DESCRIPTION OF REQUEST: Final Sign-Off, EPC-Approved SDP For Building Permit

**RE: SITE DEVELOPMENT PLAN FOR BUILDING PERMIT
UTILITY TRAILER SALES
18EPC-40004- PROJECT# 1008585**

Project# 1008585
18EPC-40004 Site Development Plan for Building Permit

ENGINEER'S SEAL	UTILITY TRAILER SALES ALBUQUERQUE NM	DRAWN BY LA
	CONCEPTUAL GRADING AND DRAINAGE PLAN	DATE 05/23/2018
	TERRA WEST, LLC 5571 MIDWAY PARK PLACE NE ALBUQUERQUE, NM 87109 (505) 858-3100 www.tierwestllc.com	2017041-GRADING 2
VINCENT P. CARRICA P.E. #16212		JOB # 2017041

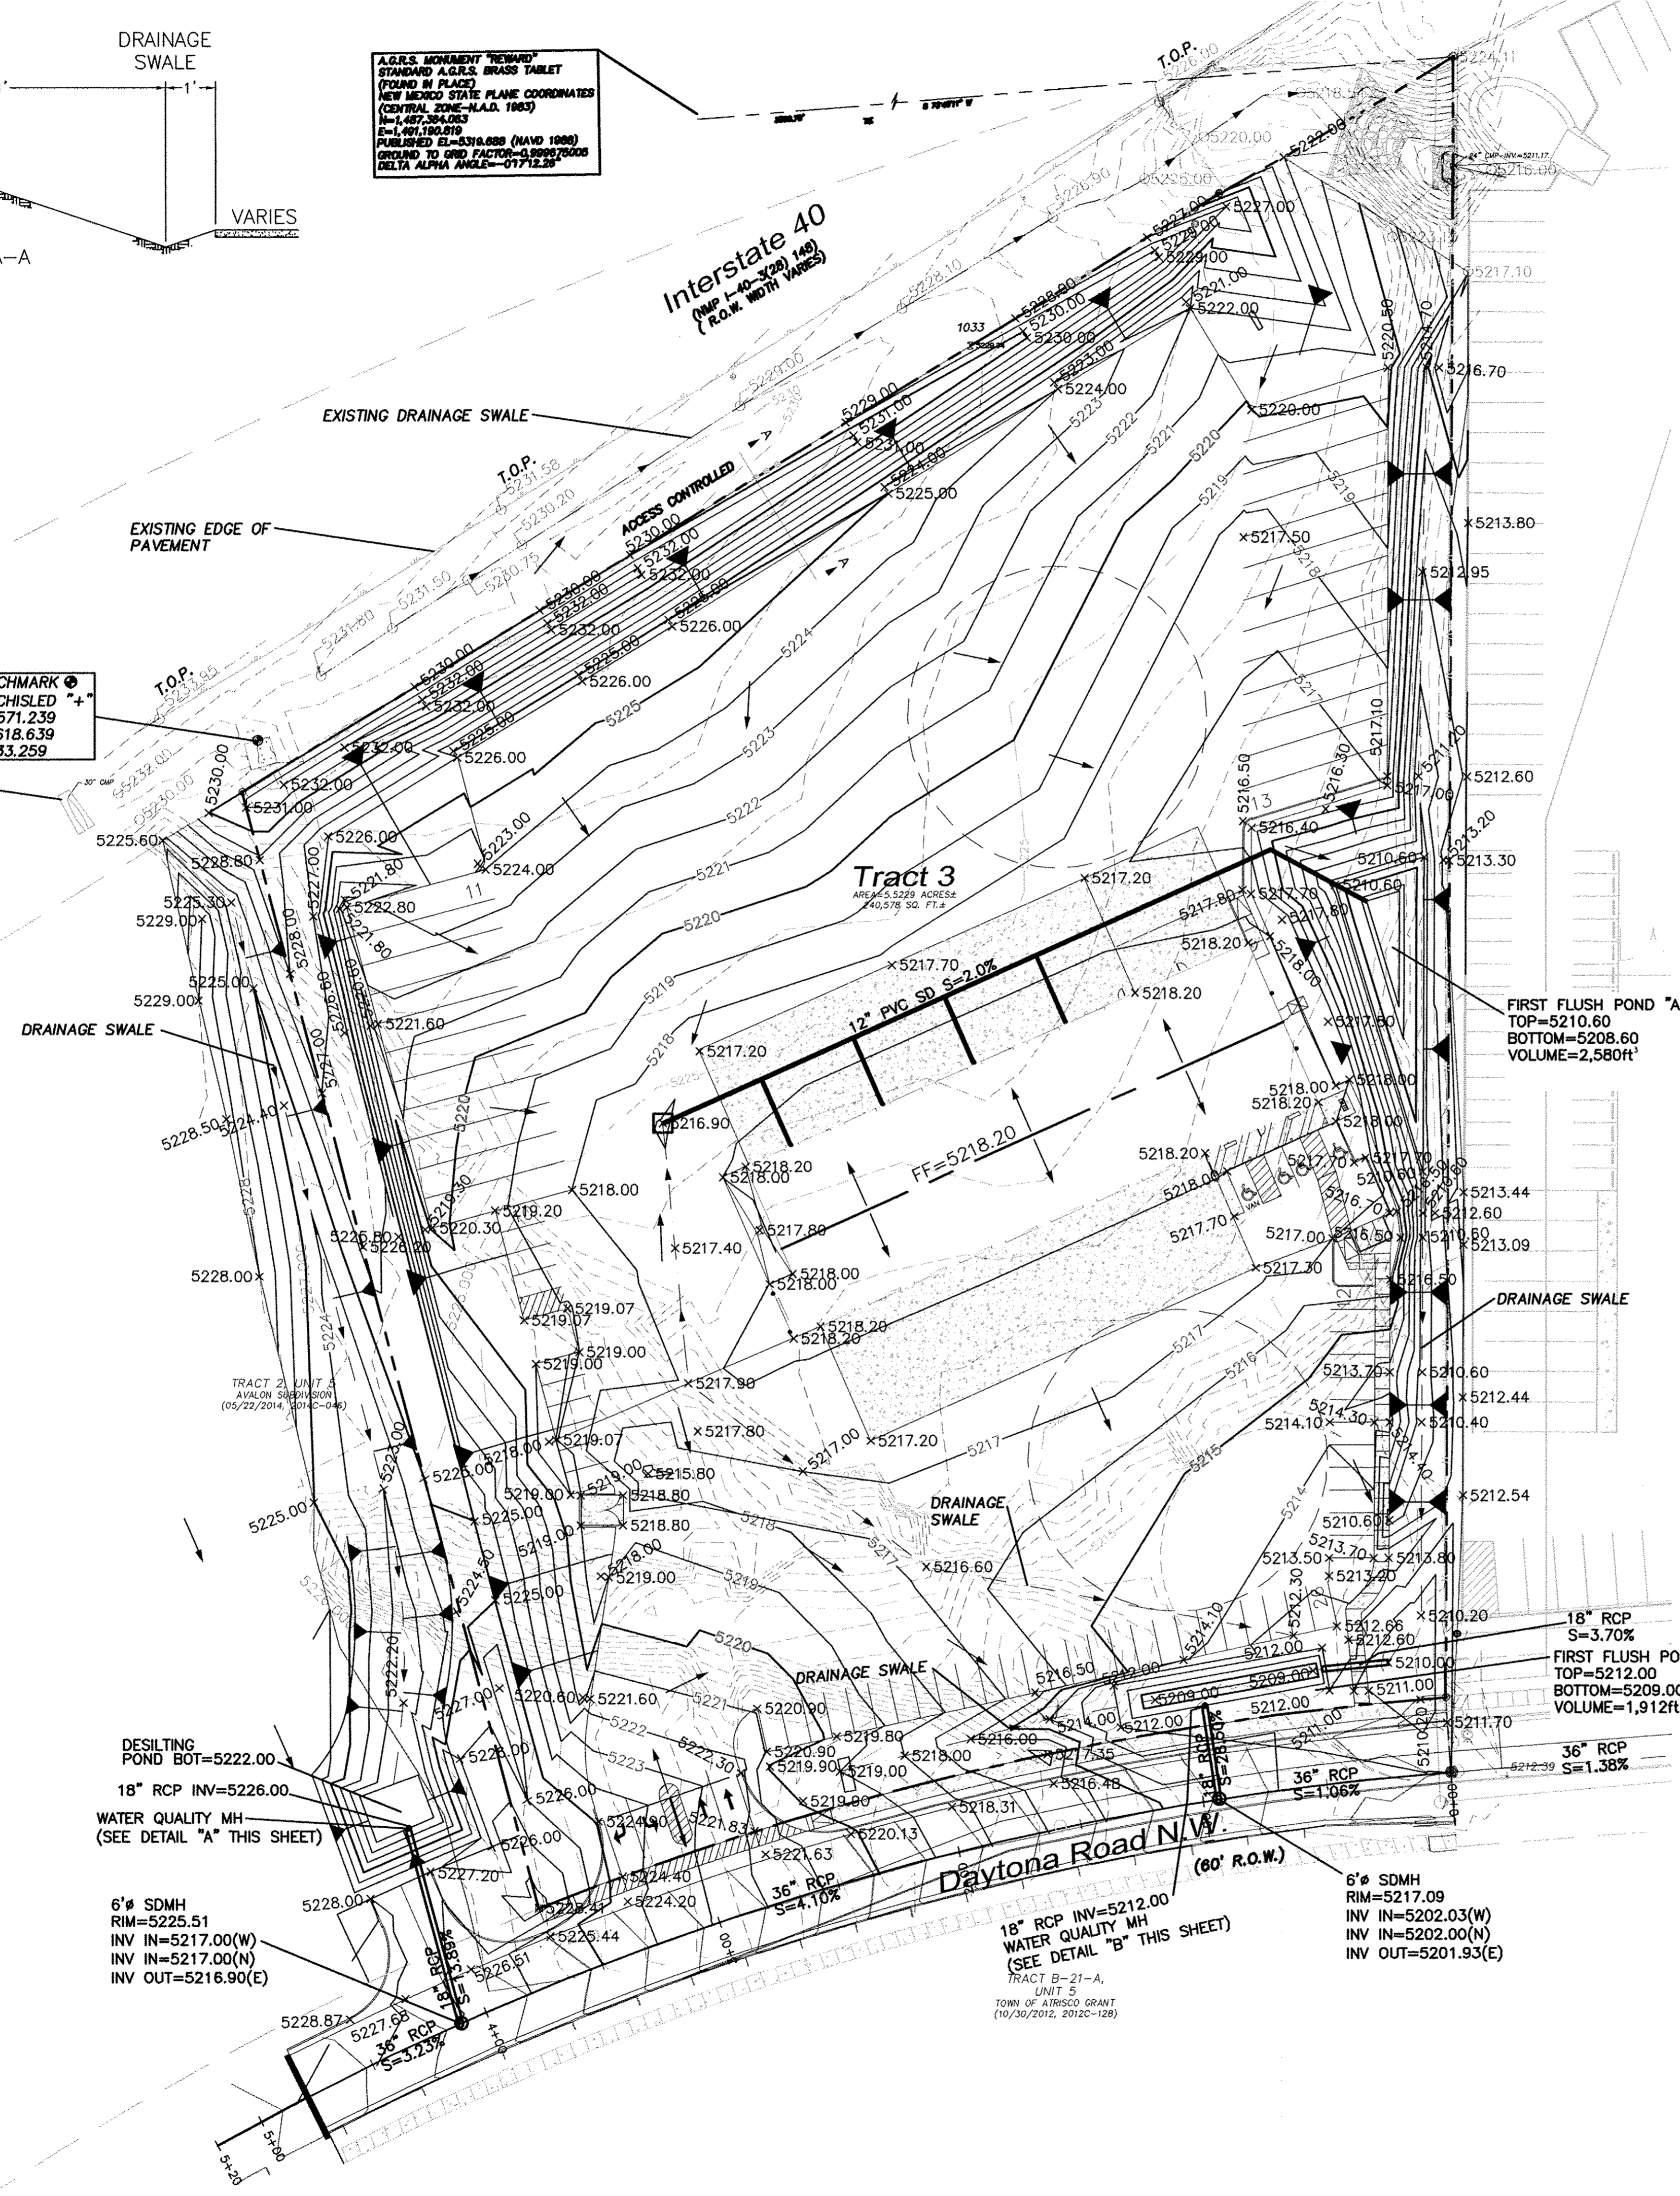
- Approved Conceptual Grading and Drainage Plan for DRB action on Site Plan for Building Permit.

Response: A Grading and Drainage Plan was submitted to City Hydrology for review and approval.

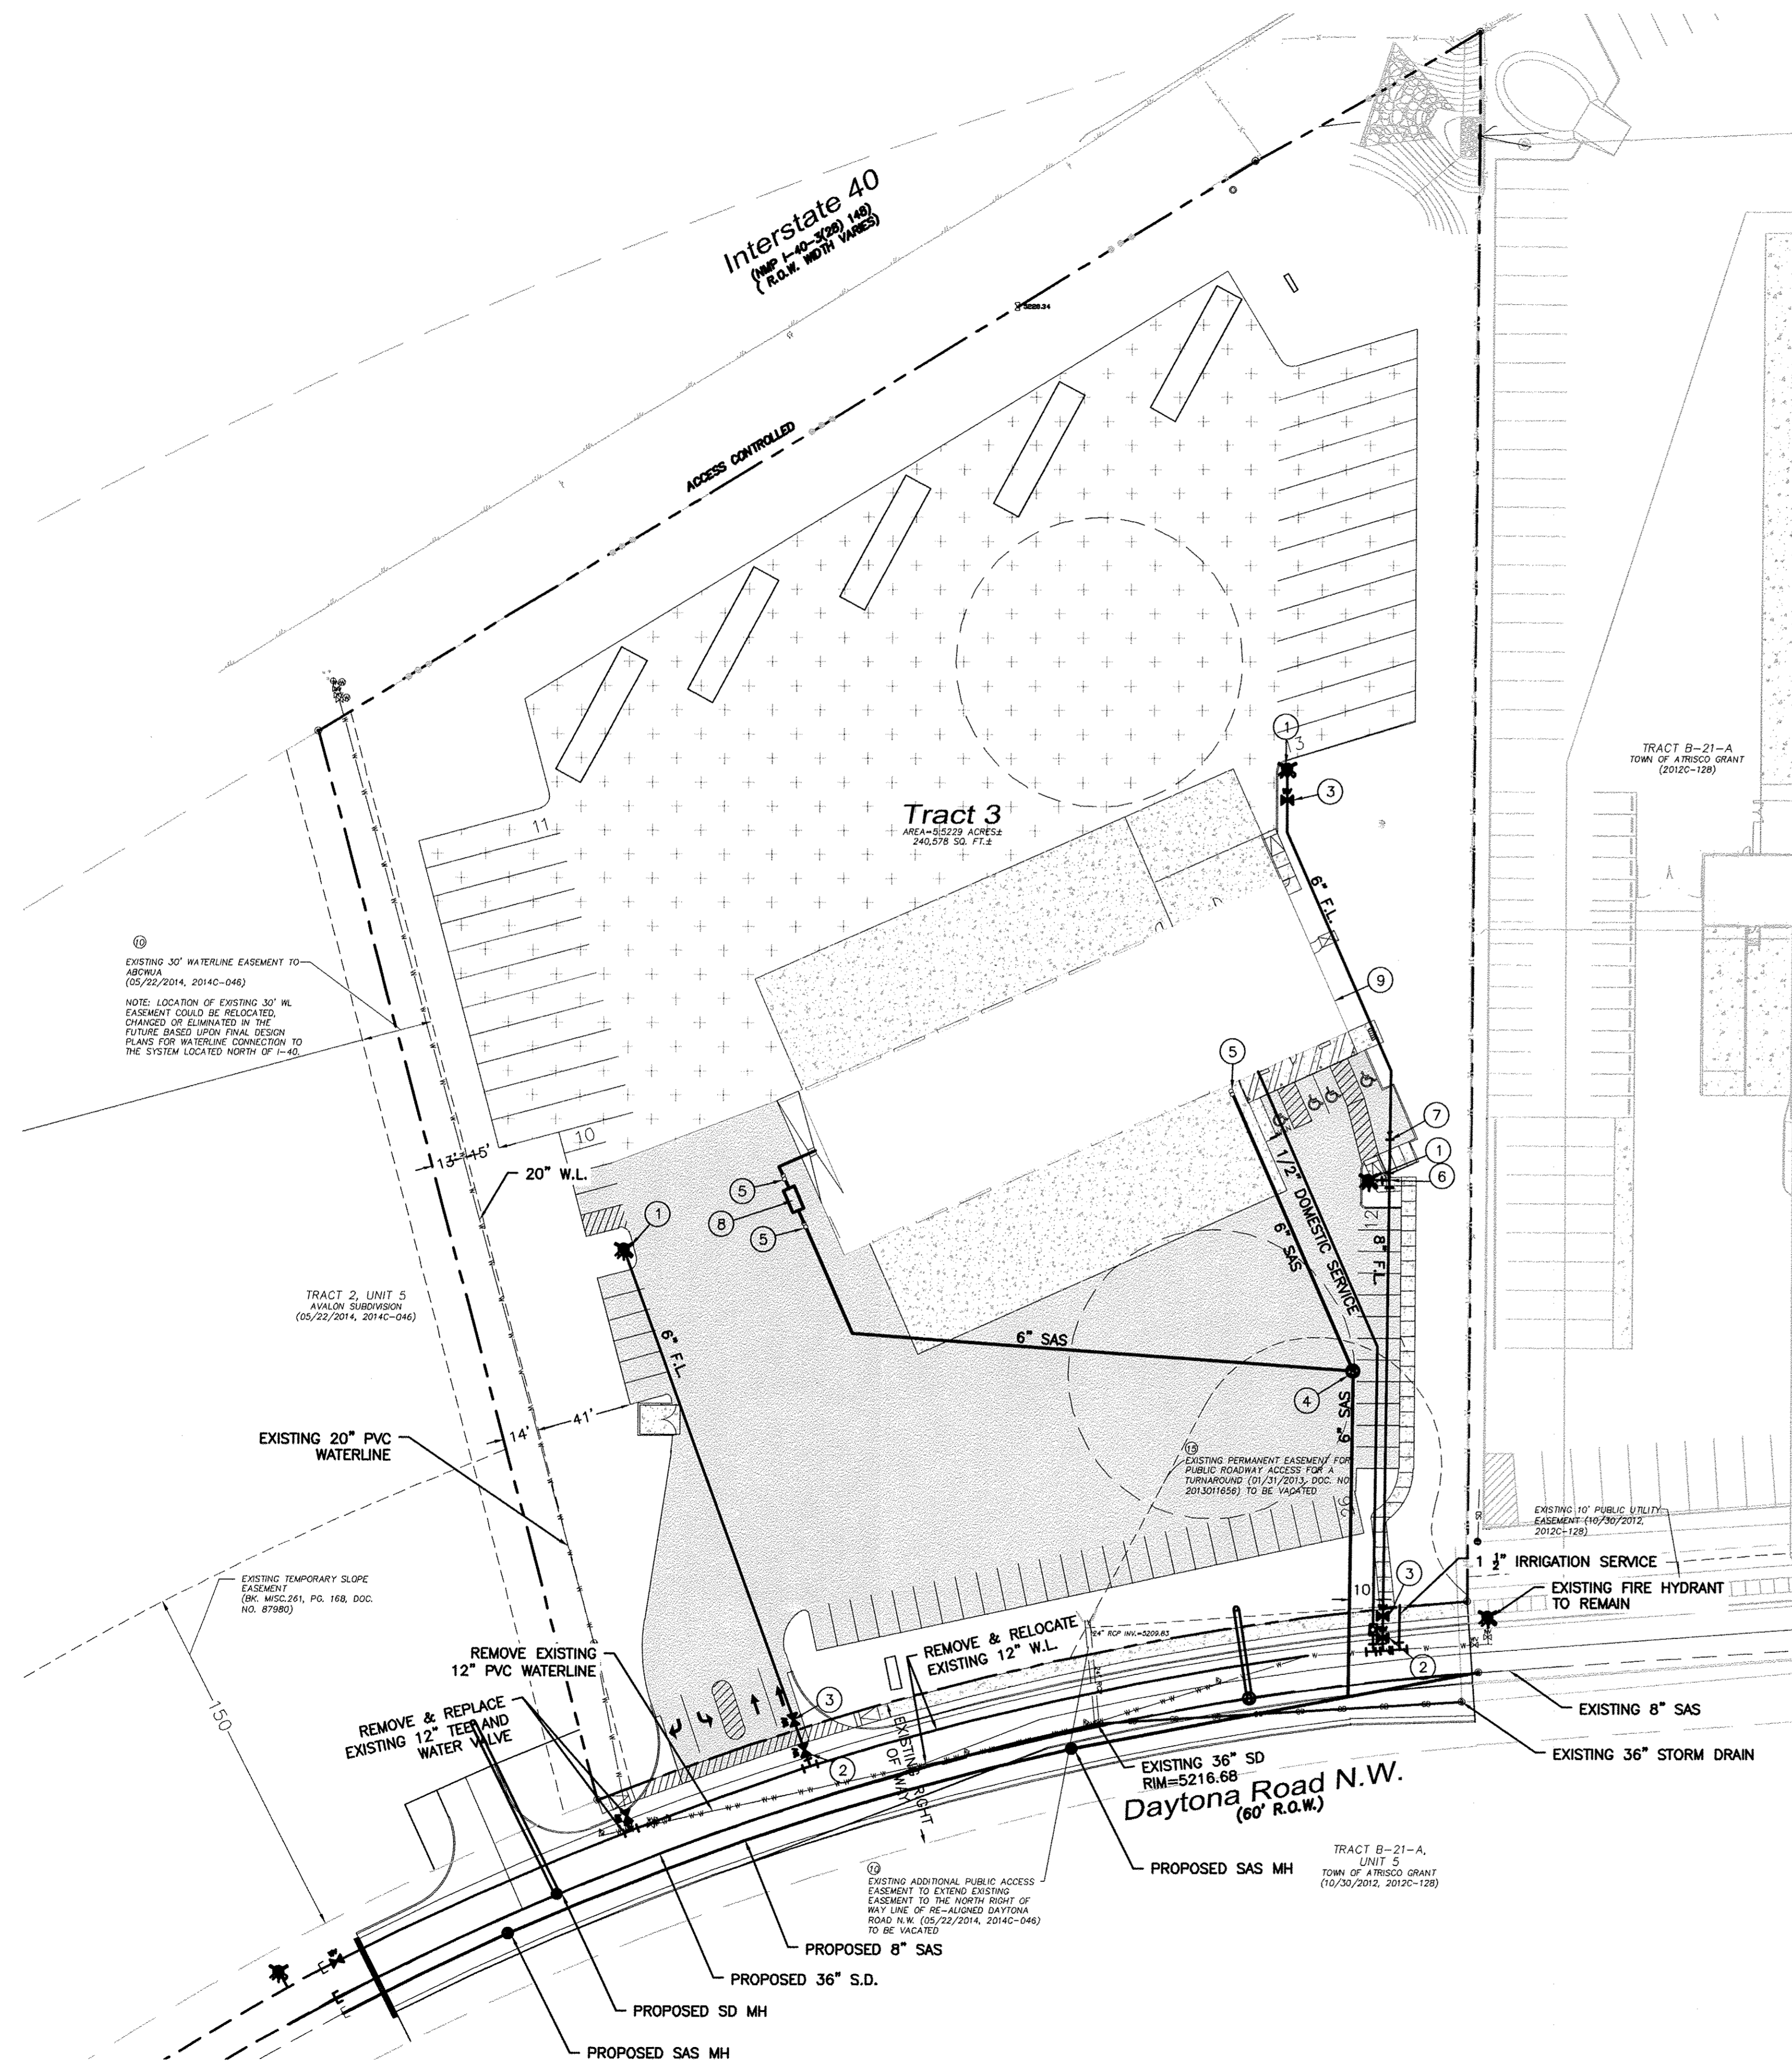
- The indicated fire line shows two hydrants. Please note that these hydrants are to be considered private and shall be painted safety orange.

- The proposed fire line connection to the 20 PVC distribution main along the west border of the site is not a permissible connection. If this hydrant is a required hydrant consider an additional connection Daytona Rd.

Response: The indicated fire hydrants are noted as private and a note was added to paint them safety orange.

Response: The fire line connection was revised to show it coming off the 12" waterline in Daytona Road.

LANDSCAPE LEGEND

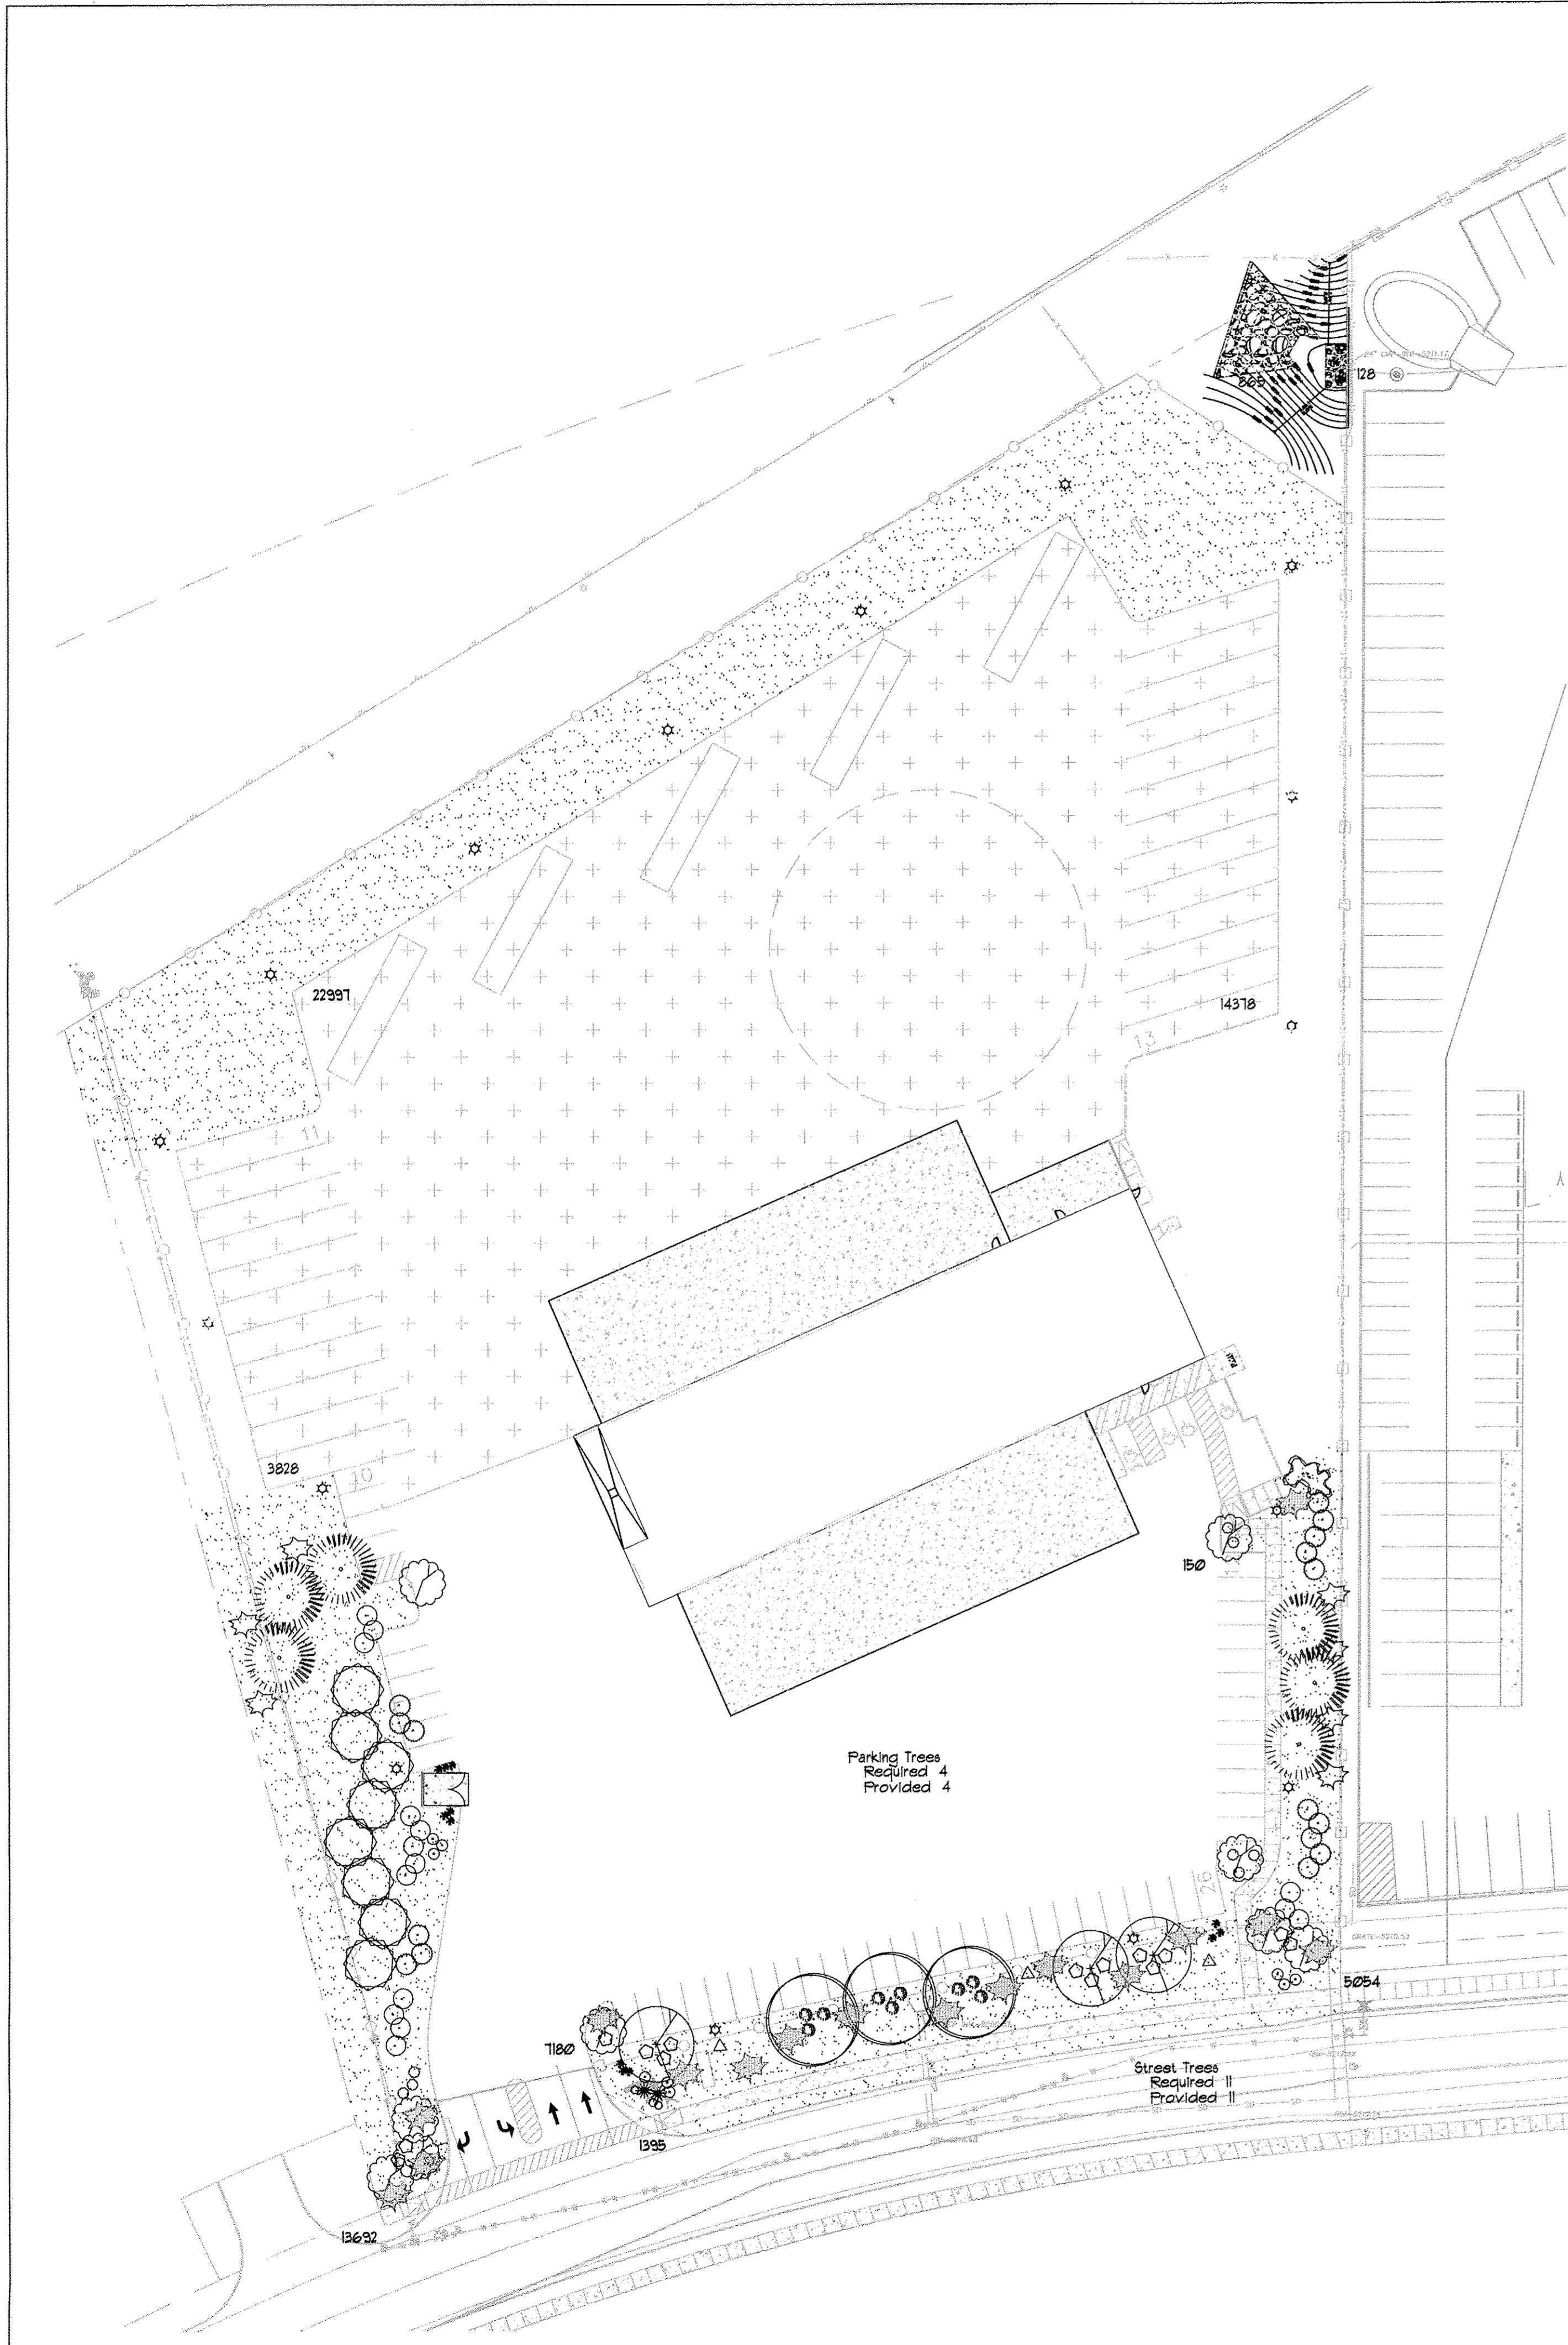
6. The back landscape areas shall be re-seeded with xeric seed mix which will result in a grass and wildflower meadow until fully established.

Response: The landscape plan was modified to show re-seeding with xeric seed mix.
